Demolition of existing garage & outbuildings. Alterations to external materials (including change from thatch to clay tiled roof and brick/stone to fibre cement weatherboarding and coloured render). Alterations to existing fenestration, including to 2 no. ground floor rear bay windows, and addition of first floor front dormer, enlarged balcony at first floor level at the rear. Replacement garages.

The Breakers 29 Tamarisk Way East Preston

Thank you for your internet representation made on 25th January 2020 which has been recorded as '**an objection**' with the comments as follows:

Elevations as Proposed

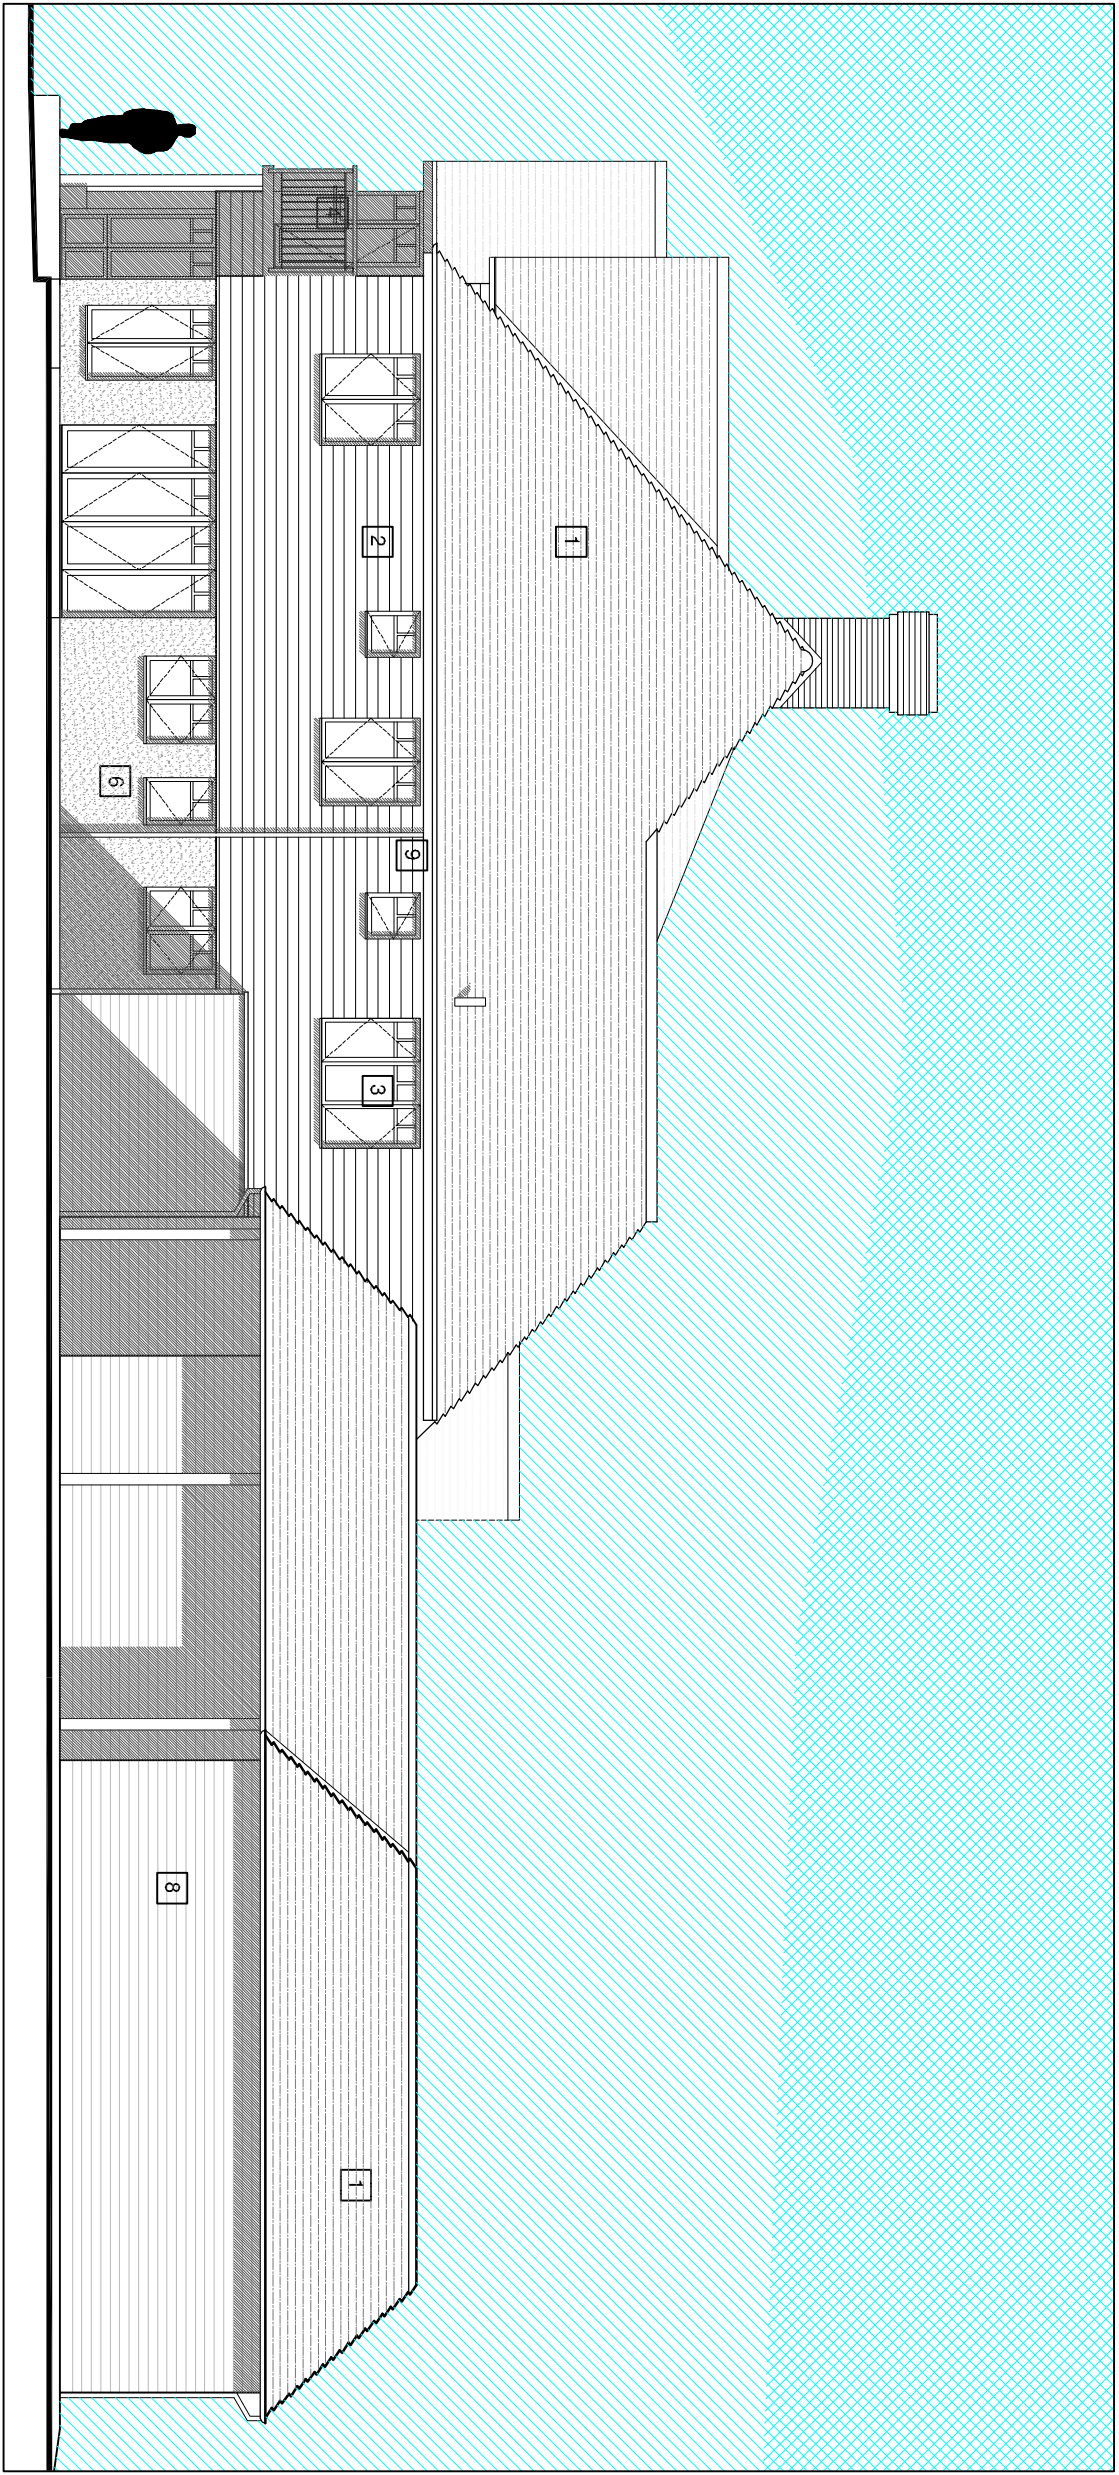
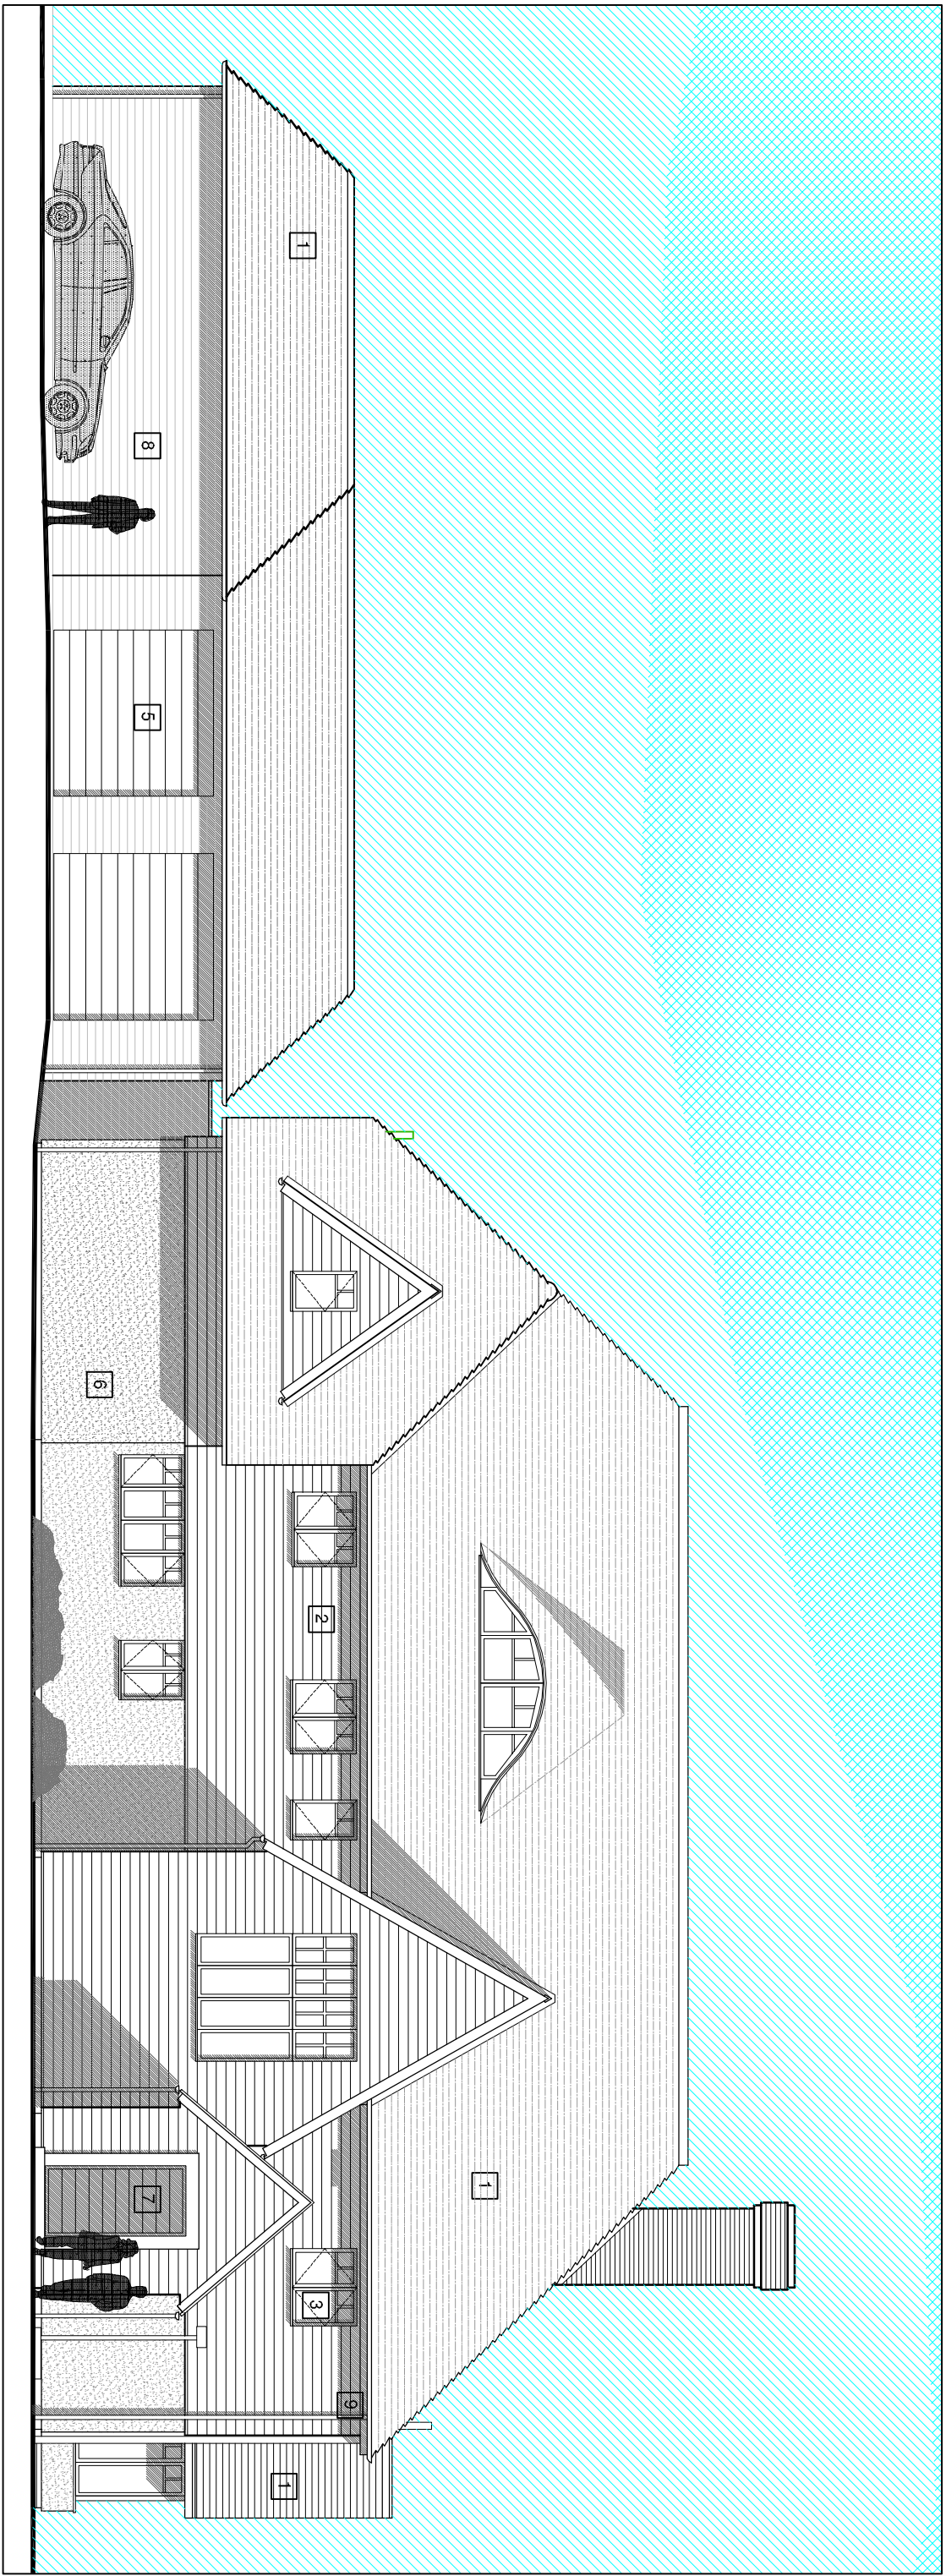
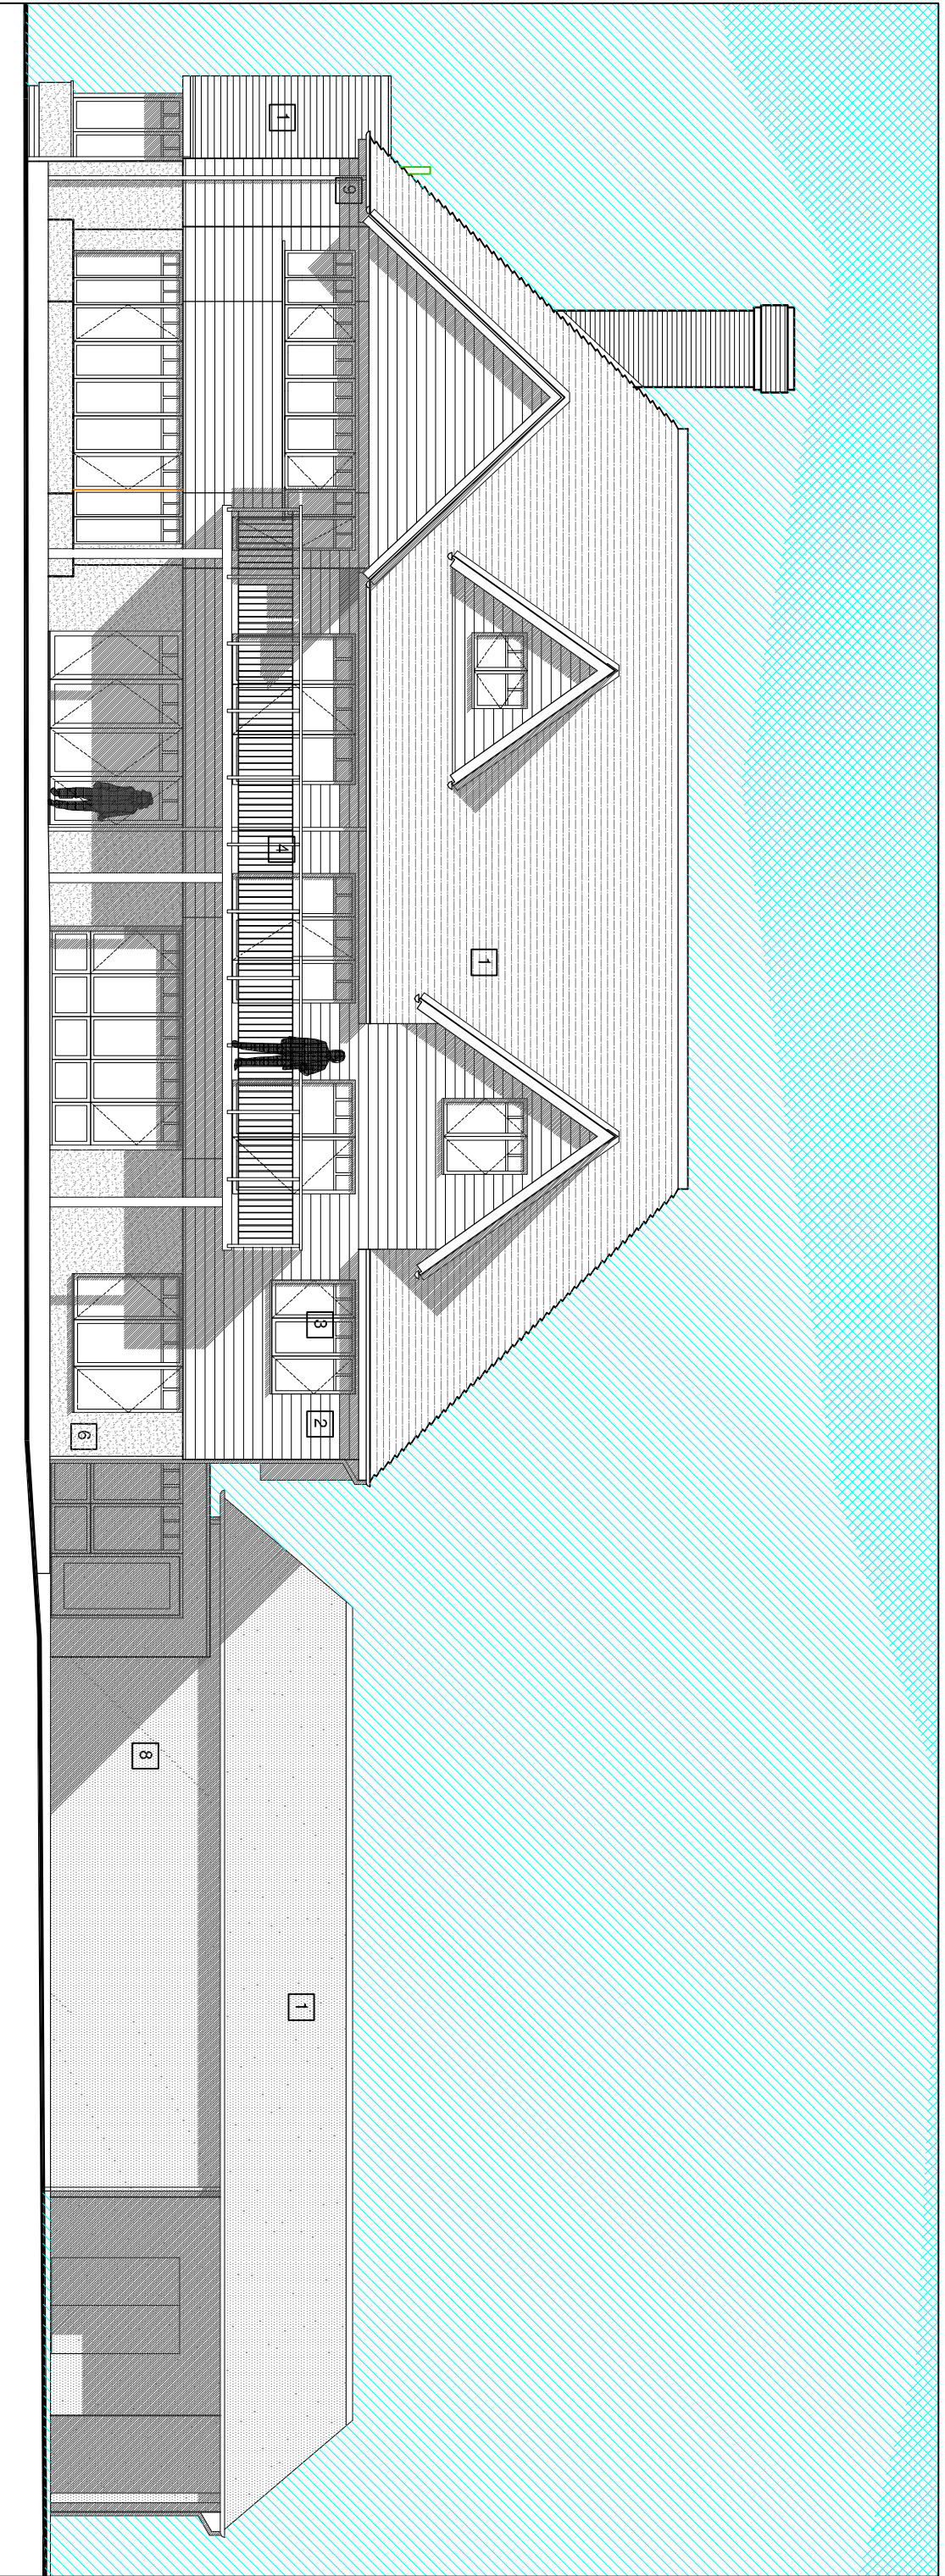
*Para.3.1 claims the property is "a hotch-potch of materials", this is clearly not the case, it presents itself as a white painted rendered building with a thatch roof and stone featured porch which is matched to the boundary wall in a characteristically open manner.*

*Replacement of this with a "New England" style property with an enclosing boundary wall, 1.95m high, would be seriously detrimental to the appearance of the area.*

*Para. 5.1 the materials proposed are completely out of character with the adjacent properties.*

*Para.6.1 the claim that replacing the thatch with the tiles will give a 100% increase in the insulation values is hard to justify. Normal modern thatch has a thermal resistance, R value, of around 5, that of the proposed clay tiles is likely to be less than 1, that is 500% worse than the thatch, so any improvement will have to be achieved by the use of secondary insulation which could likely be achieved without replacing the thatch. The windows were only replaced a few years ago, by the previous owner, with hard wood framed double glazed units, it seems unlikely that any significant improvement will be achieved with the proposed replacements. From an environmental point of view the thatch is more friendly as it is 100% carbon neutral, the replacement tiles will result in the emission of significant CO2.*
